CITY OF ALBUQUERQUE

PLANNING DEPARTMENT – Development Review Services

RE: 3901 Masthead St. NE
Grading & Drainage Plan
Engineer's Stamp Date 9-26-2016 (File: D17D095)

## DRAINAGE AND GRADING PLAN 3901 MASTHEAD STREET NE

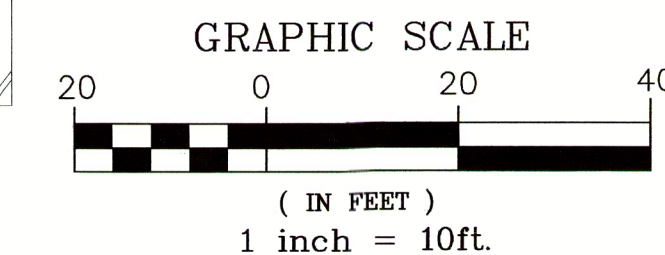
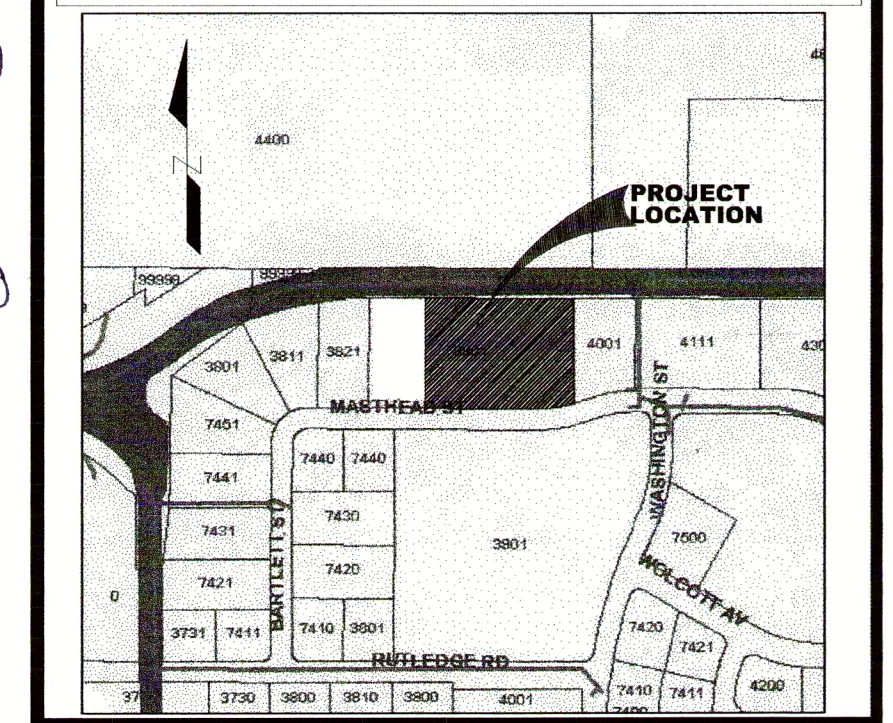
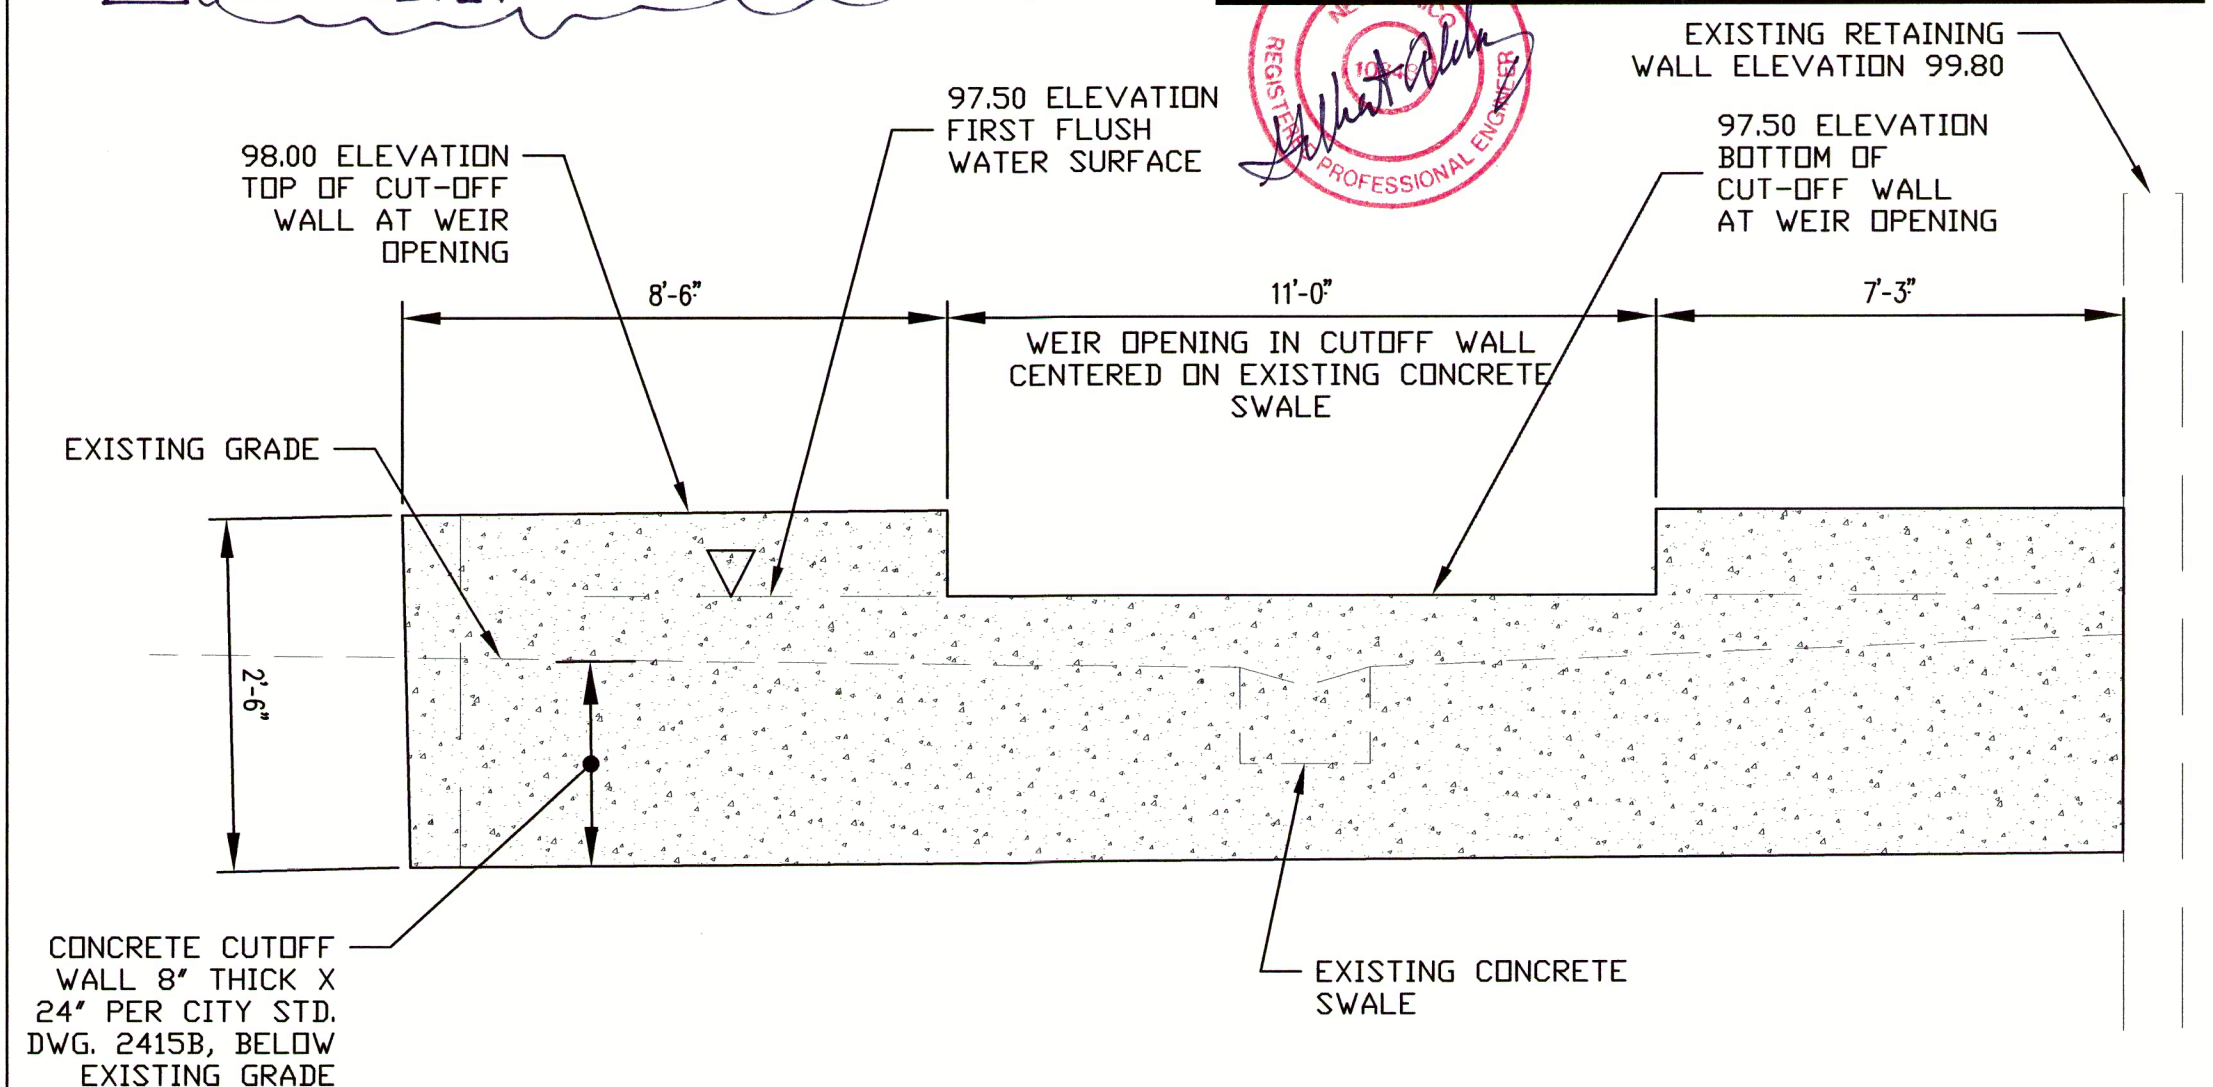
- Keyed Note 5 states that pond side slopes are at 2:1. It infers that all sides are at 2:1, but rip-rap is only shown on 2 sides. All slopes steeper than 3:1 require rip-rap per DPM. Prior to C.O. rip-rap should be on all sides of pond.
- Edit the leader of Keyed Note 3. It is not pointing to the location of the weir, which is on west side of pond.
- Edit Keyed Note 15 to ensure the ESC BMP is implemented before /during construction, but not required once it is built. Please ensure contractor implements the BMP.
